RE: Hatlestad Short Plat (SP-06-113)

The Kittitas County Community Development Services Department has determined that the Hatlestad Short Plat is a complete application and hereby grants **conditional** preliminary approval subject to the following conditions:

HATLESTAD SHORT PLAT
PART OF SECTION 16, T. 18 N., R. 18 E., W.M.
KITITAS COUNTY, WASHINGTON

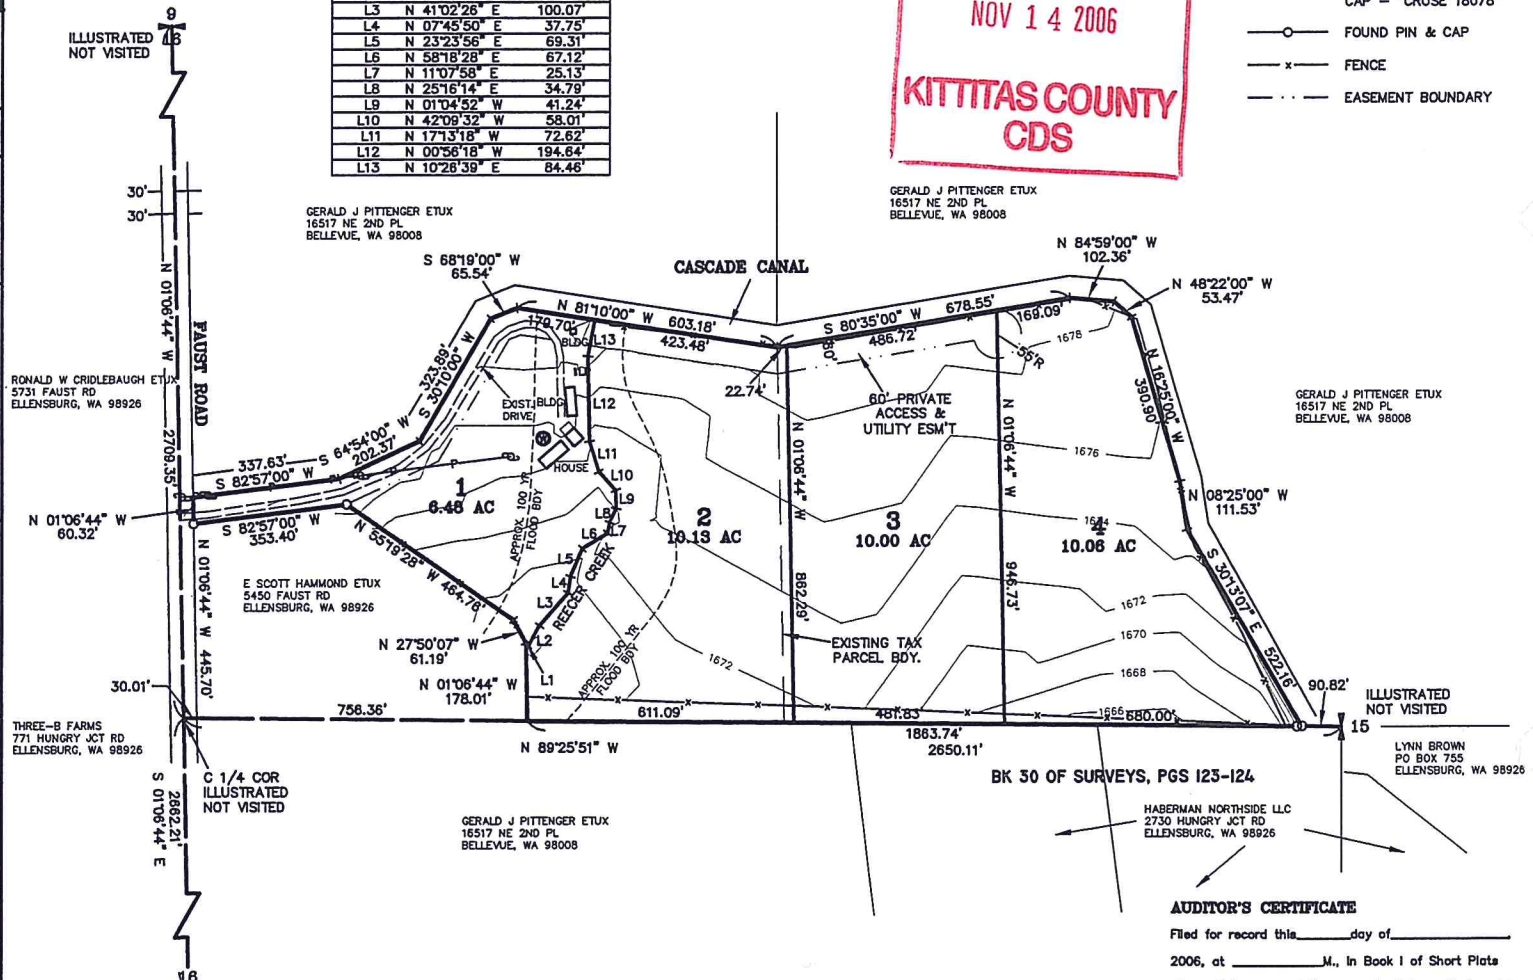
1. Both sheets shall reflect the short plat number SP-06-113.
2. All future development must comply with International Fire Code (IFC) and appendices.
3. All Kittitas County road standards must be met. Attached you will find comments from Kittitas County Public Works. Please contact Christina Wollman at 962-7051 regarding all road standards and access questions.
4. Attached you will find comments from Kittitas County Environmental Health. Please see those documents for required plat notes and information on issues needing completion before final approval of this short plat.
5. Submittal of a Certificate of Title (Title Report) with the final short plat mylar.
